We have received the proposed Sage Short Plat, located in Section 32, Township 19, Range 18, off of Lower Green Canyon Road. We have also received the \$376.88 plat submission fee (receipt #49742 & 49746).

TO: Mary Rill, Community Development Services
FROM: Christina Wollman, Planner II *cw*
DATE: March 7, 2007
SUBJECT: Wilson, Range, Sage and Richard Short Plats

SHORT PLAT APPLICATIONS SP-07-12 - SP-07-15 - SP-07-13

SAGE SHORT PLAT

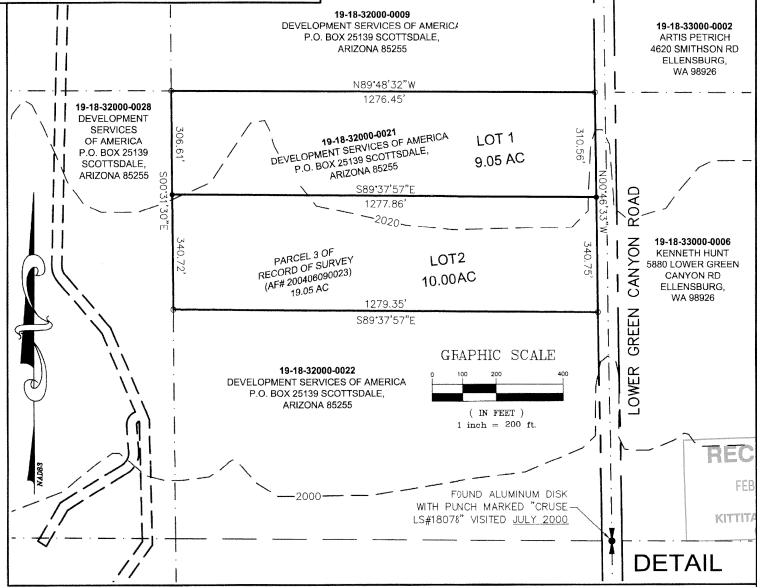
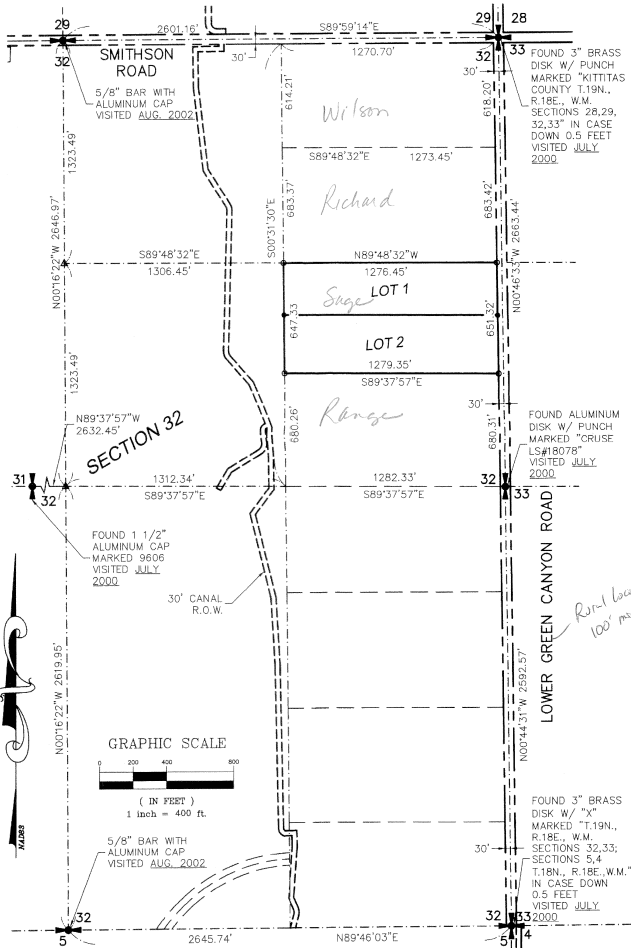
2. Access: An approved access permit will be required from the Department of Public Works prior to creating any new driveway access or performing work within the Smithson Road and Lower Green Canyon Road rights-of-way. Smithson Road is classified as Rural Minor Collector and accesses must meet the 300' spacing requirement. Lower Green Canyon Road is classified as Rural Access and accesses must meet the 100' spacing requirement.

3. Driveway Access for Wilson, Richard and Sage Short Plats: Kittitas County Department of Public Works encourages the use of joint-use driveways in order to reduce the number of access points on Smithson Road and Lower Green Canyon Road. However, accesses into Lots 1 and 2 of the Wilson, Richard, and Sage Short Plats may be through the use of

6. Plat Notes: Plat notes for each short plat shall reflect the following:
 - a. Plat note #3 is incorrect and shall be removed.
 - b. Maintenance of the access is the responsibility of the property owners who benefit from its use.

8. Plat Approvals: All plats must show the acceptance signature of the County Engineer. The acceptance block shall be as follows (per KCC 16.24.170):
